20 July 2021

RE: LLFA Response – 6/2020/3222/MAJ, Former Volkswagen Van Centre, Comet Way, Hatfield, AL10 9TF

Stantec Drawing 47179/4001/002 Surface Water Drainage Strategy

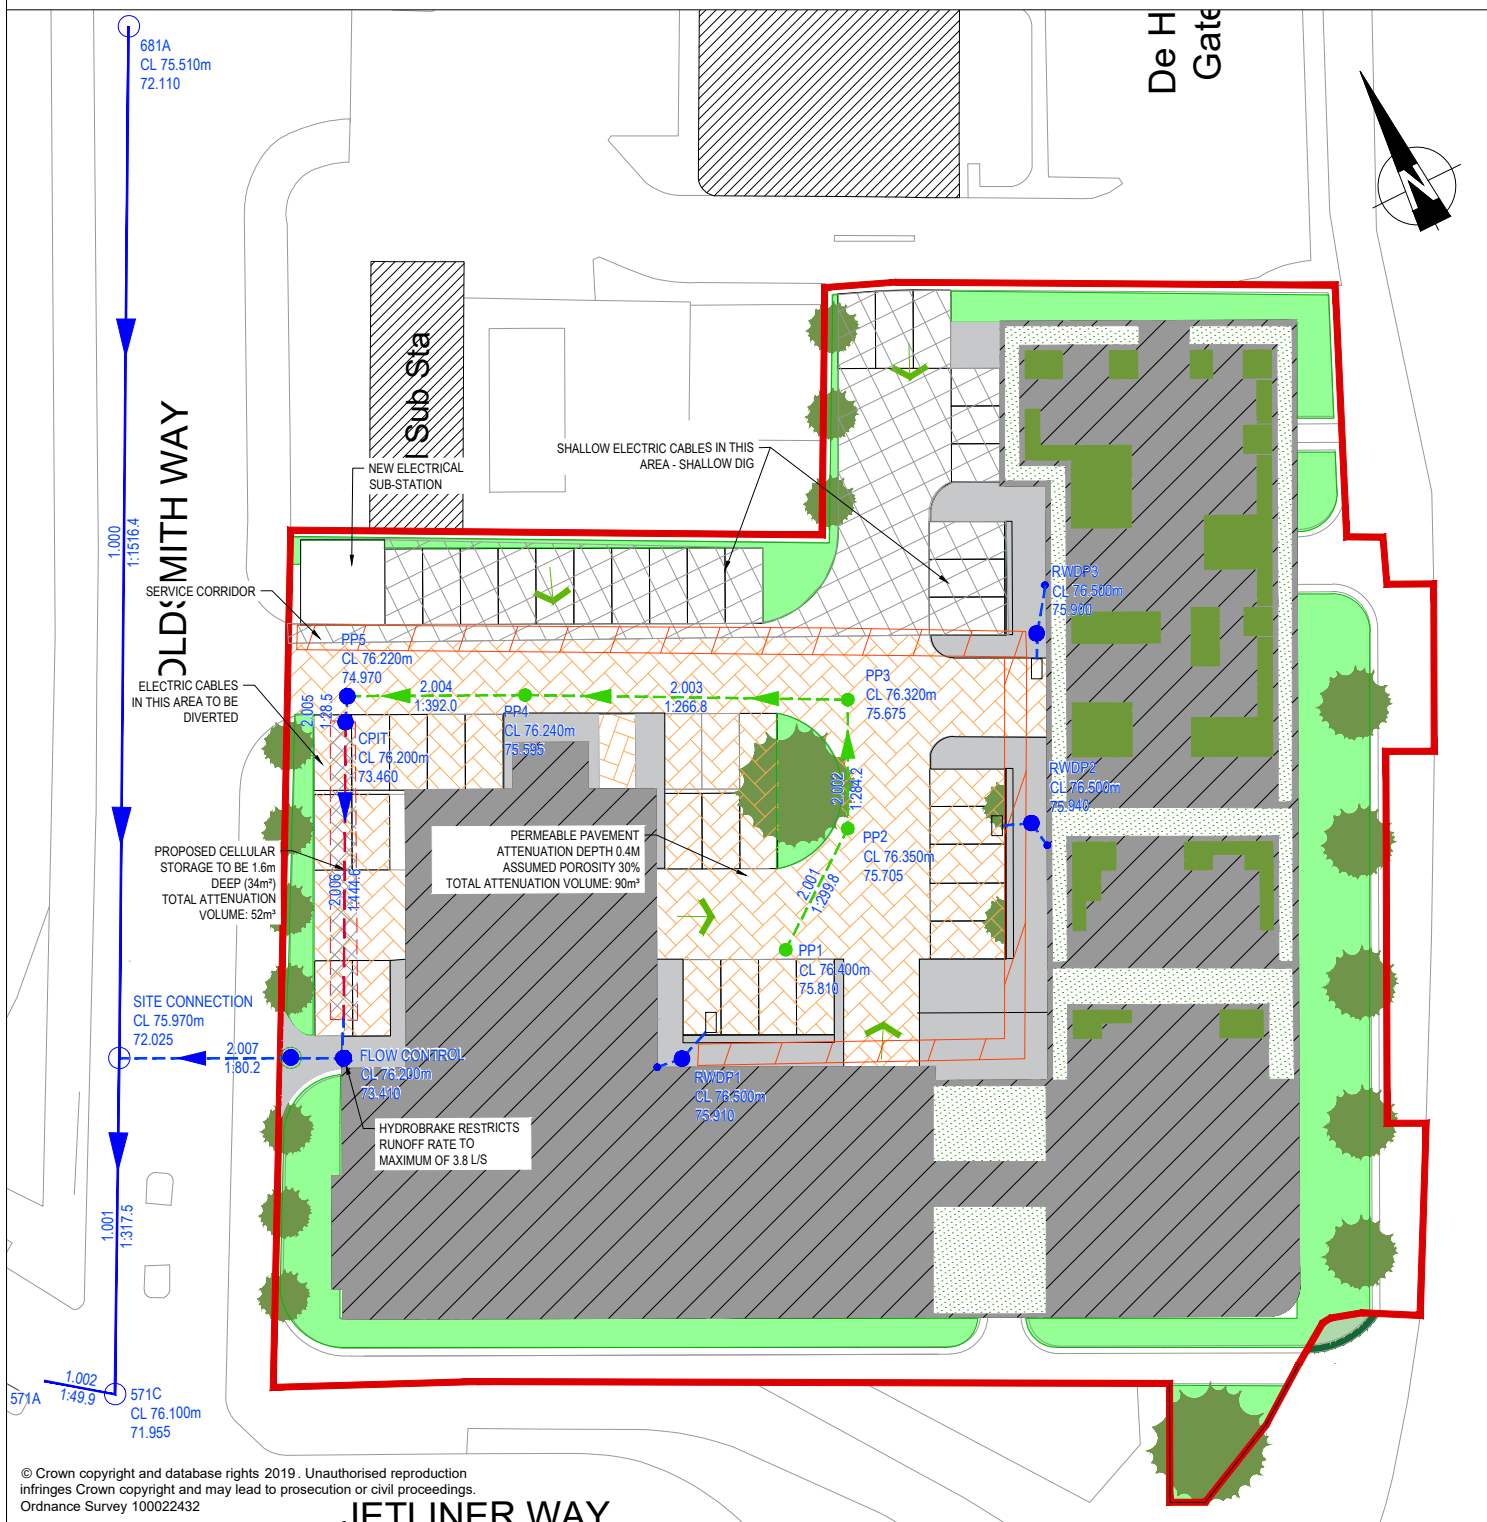
Although we feel the request by HCC to limit discharge rates to 2 l/s is unreasonable, we attach updated MicroDrainage calculations applying the restriction of this lower runoff rate. This demonstrates that the size of the tank would need to be increased from 34m² to 75m².

We have reviewed this against the space available within the adjacent parking area and to provide a tank of this size would require wrapping the tank around the building with a smaller easement and offset than we had previously shown (reduction of 1.7m). The size of the tank would be of a larger scale and likely to result in higher maintenance and tank replacement costs, especially with the offsets to the proposed building and underground services. Our drainage strategy drawing has therefore been updated to provide this larger tank as required by HCC.

The applicant has clarified that the footpath areas to the east and south of the building are proposed to drain unrestricted to existing highway drains in Comet Way and Jetliner Way.

As these areas are within the red line boundary they should be included in the drainage proposals and discharged at a controlled rate (as above) to an appropriate location.

Please note that if it is proposed to drain these areas to highway drains that we would require evidence of agreement in principle from Highways confirming they are happy to accept discharge into their network.”

Whilst an existing footpath isn't currently present along the southern boundary of the site, this area is predominantly impermeable and drains to this highway drain as proven by the services survey to either MH671F or MH671B, as shown in our letter dated 01 June. It is therefore proposed to dispose of surface water runoff unattenuated via an aco-drain channel along the southern edge of the new footway to MH671F prior to discharge into the existing drainage system.

The drainage drawing has been updated and appended to our letter to further highlight the drainage for these locations.
